Your ref:
Our ref: 24/00587/LB
Please ask for: Charlie Collier
Direct dial:
E-mail: borough.planning@west-norfolk.gov.uk

Details: **This is a Rear Extension to the original property consisting of One Single Storey extension and One Double Storey extension. at Deanscroft High Street Stoke Ferry King's Lynn Norfolk**

CLIENT	-
ADDRESS	Deanscroft House, High Street, Stoke Ferry, PE33 9SF
TITLE	LOCATION PLAN SITE PLAN FLOOR PLANS
PROJECT STATUS	PLANNING DRAWING
DATE	JAN 2024
REVISION	As Indicated @A1
SCALE	As Indicated @A1
SHEET No.	PL001
REFERENCE	0010/20/FA
DRAWN BY

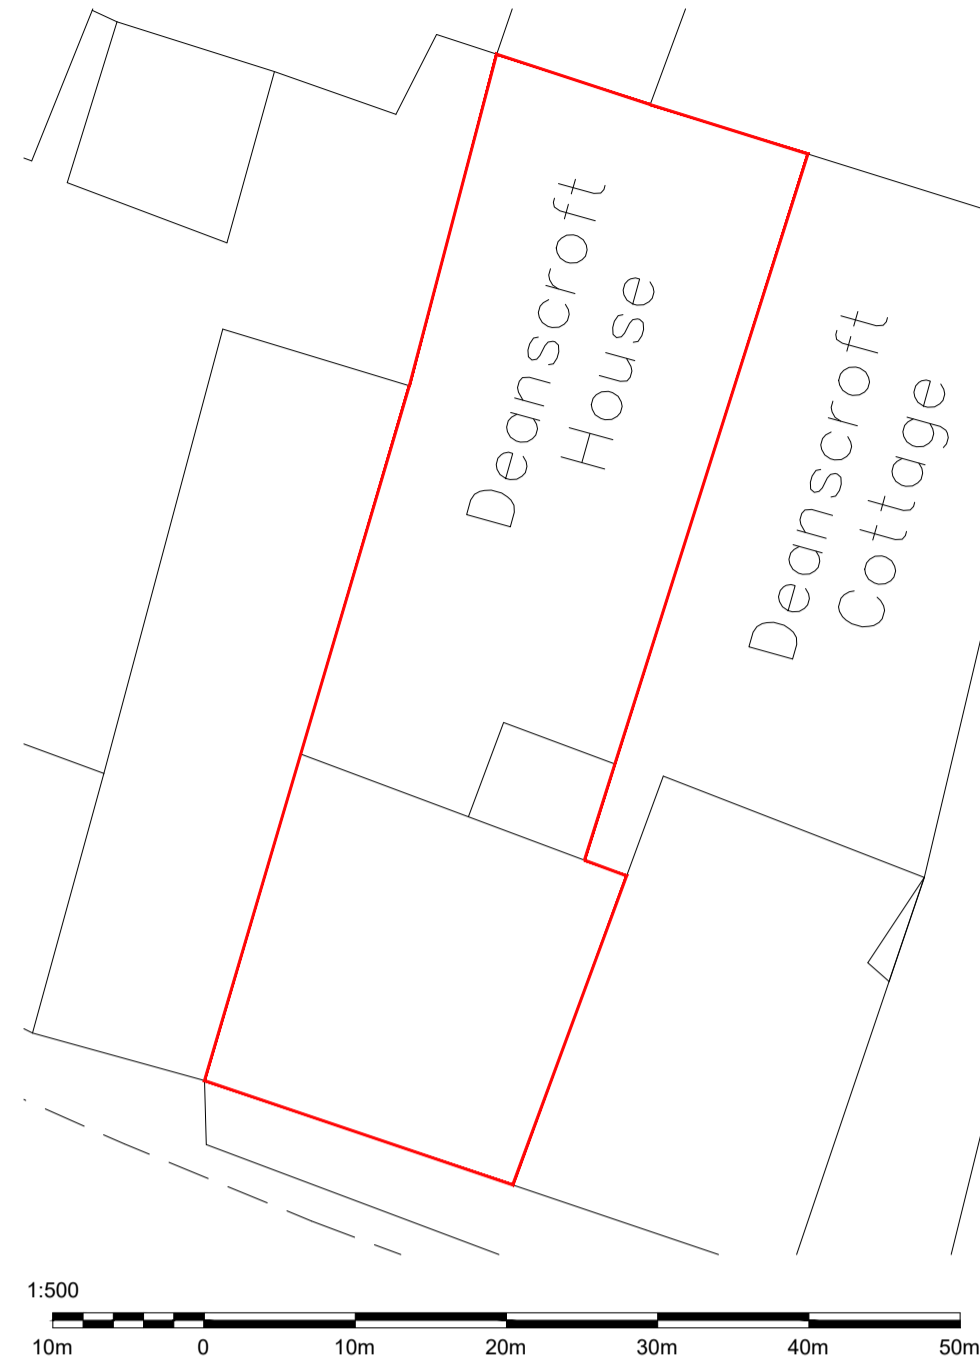
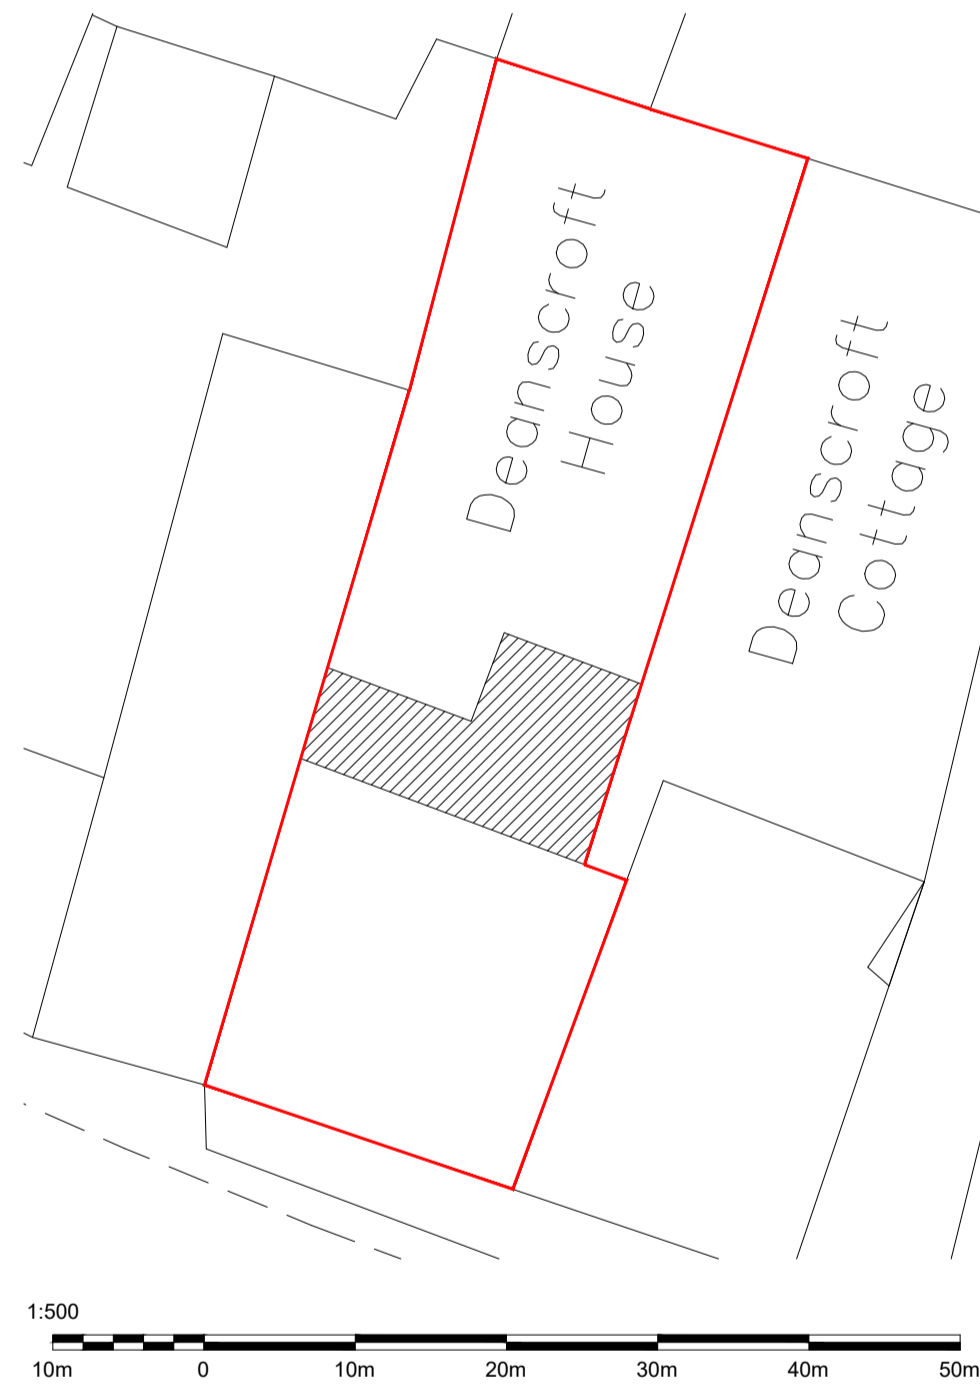
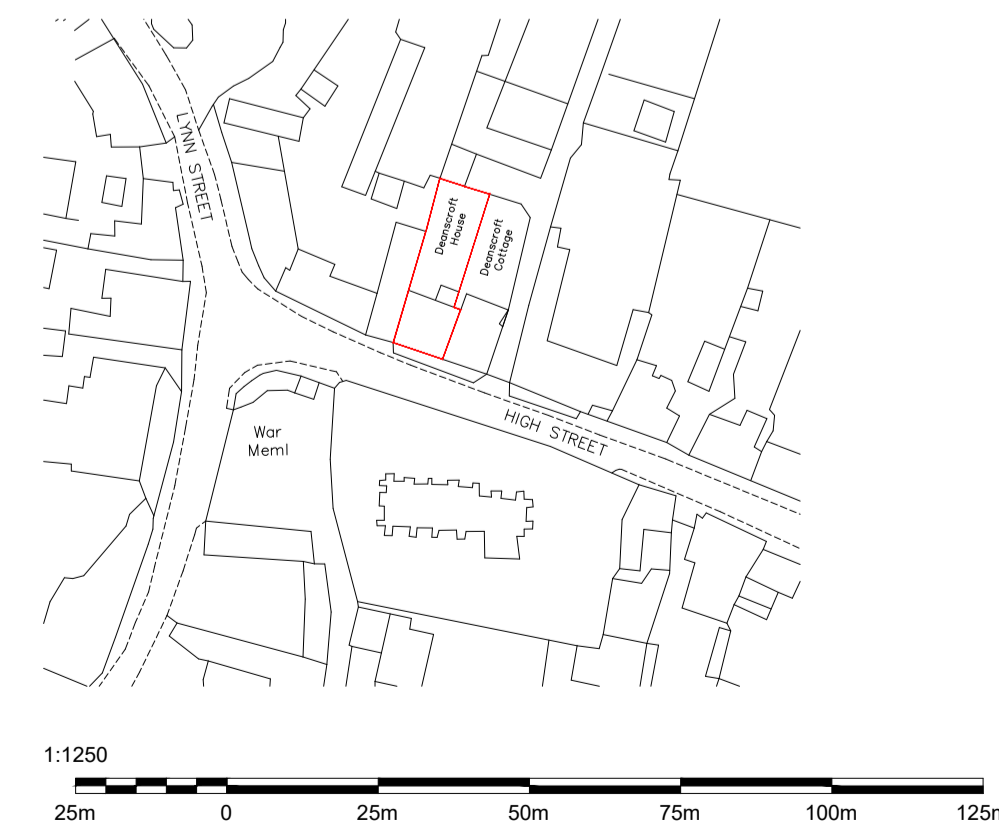
1. It appears both the site plan and location plan are not to scale, please can you amend and resend.
2. Please provide a supporting heritage statement to support this application.
